Recommendation Report for Planning Permission for Works or Extension to a Dwelling

REF NO: P/128/25/HH

LOCATION: 5 Downlands Close  
Paghham  
PO21 3QA

PROPOSAL: Single storey rear extension with skylight and garage conversion.

Mr. & Mrs. Leadston
 5 Downlands Close, Pagham
 West Sussex PO21 3QA
PROPOSED ELEVATIONS
 A3 PAPER
 Date: Aug. 2025 Scale 1:100 Dwg.no. PR.EL. 01

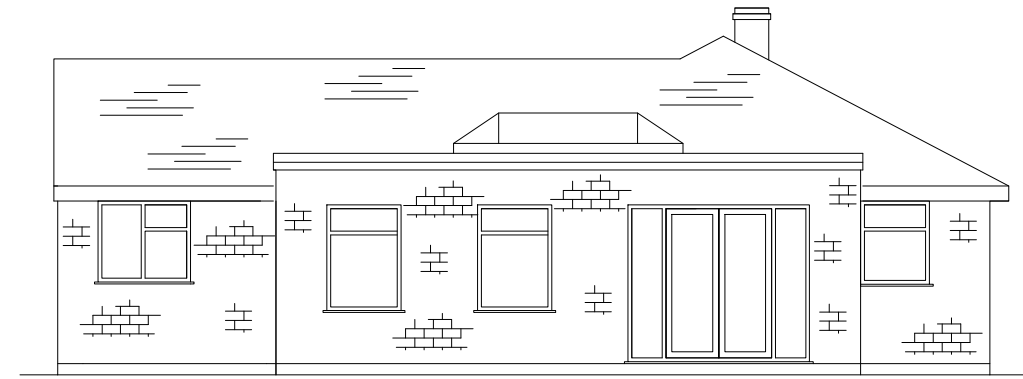
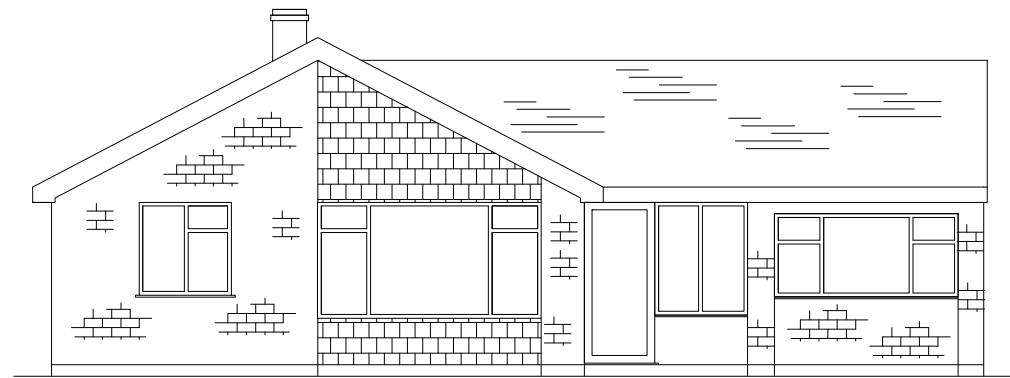
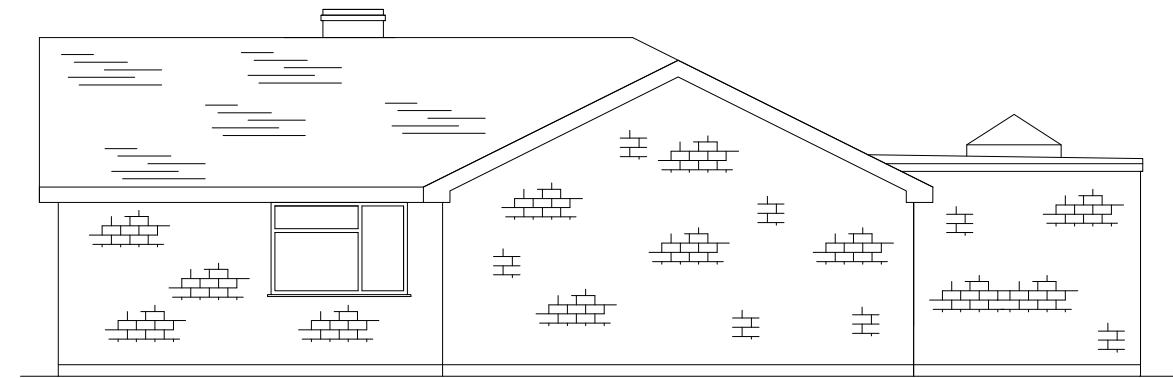
The proposal involves the construction of a single storey rear extension and the part conversion of the existing garage into habitable accommodation. The existing rear conservatory would be demolished and replaced with the proposed extension, which would measure approximately 7.7m in width, 3m in depth, and would have a maximum height of 3m with a flat roof form.

The extension would feature patio doors opening onto the rear garden, flanked by two windows within the rear elevation, and a lantern-style rooflight within the flat roof section.

The garage conversion would retain its existing footprint, with the only external change being the addition of a uPVC window on the front (west) elevation. This window would match the existing fenestration and remain visually subservient to the host dwelling and as such is in accordance with the guidance set out in the Arun Design Guide.

A window is proposed within the northern flank of the proposed extension. Given the spacing maintained between the proposed extension and the northern side boundary and the ground floor siting of the proposed window, the proposed window would not result in any overlooking. Concerns have been raised regarding potential overlooking from the proposed rear (eastern) fenestrations. The rear extension would be set back approximately 9.2m from the rear boundary, and neighbouring properties to the rear are set in from the shared boundary with the application site. Furthermore, there is existing close boarded fencing and vegetation along the rear boundary, given the ground floor siting of the proposed rear fenestration, and that the extension would replace an existing conservatory of the same depth, the proposal would not result in additional overlooking when compared with the existing situation. Therefore, conditions restricting windows or requiring screening would not be necessary or appropriate in this instance as the development would not result in significant harm to neighbouring properties by way of overlooking.

Mr. & Mrs. Leadston
 5 Downlands Close, Pagham
 West Sussex PO21 3QA
 SITE PLANS
 A3 PAPER
 Date: Aug. 2025 Scale 1:200 Dwg.no. SP. 01

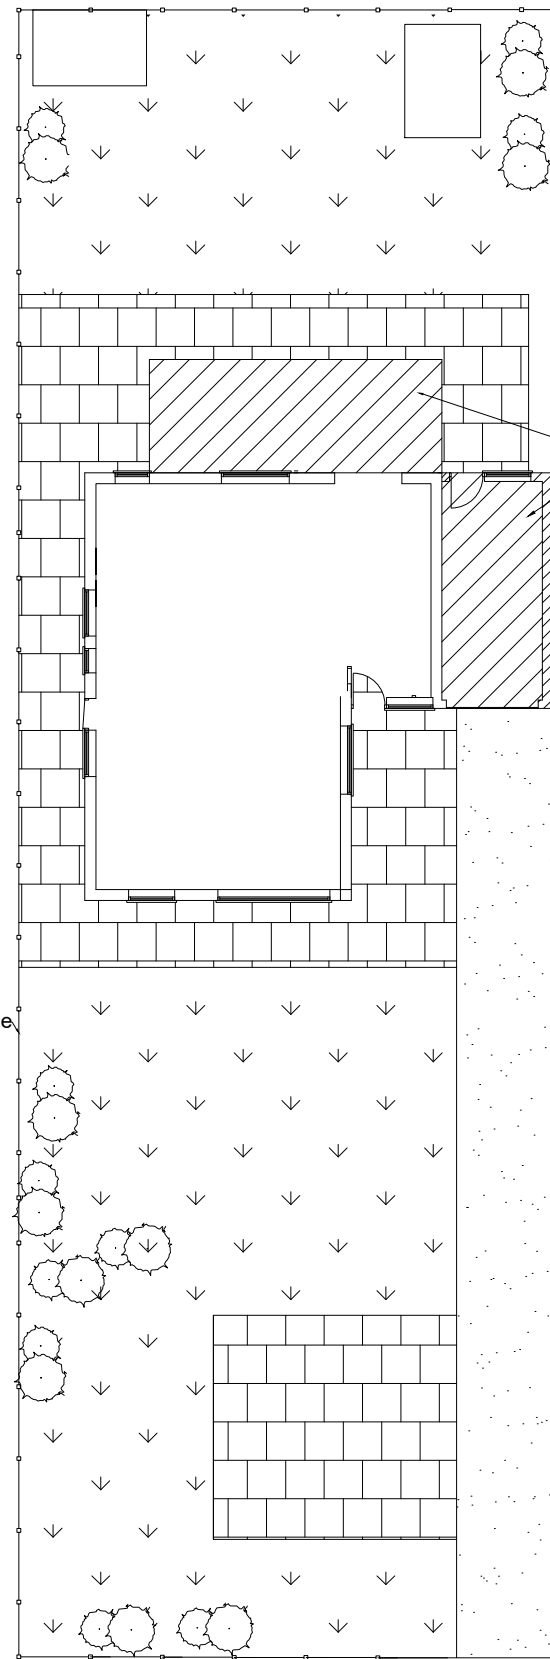
The rear extension would be set in approximately 4.6m from the northern (side) boundary and 2.6m from the southern (side), maintaining adequate separation from the adjacent dwellings. As such, the proposed extension would not result in overbearing or overshadowing impacts to neighbouring properties.

It is acknowledged that the proposal does not fully comply with the Arun Design Guide in terms of garden amenity space, with a remaining depth of approximately 9.2m. This is consistent with the existing situation due to the current conservatory. The shortfall is therefore acceptable in this regard.

The application site is located within Parking Zone 2 and as per the Arun Parking Standards, the dwelling is required to provide 2 parking spaces. The loss of the existing garage space to habitable accommodation would be acceptable as the existing driveway to the front of the property can
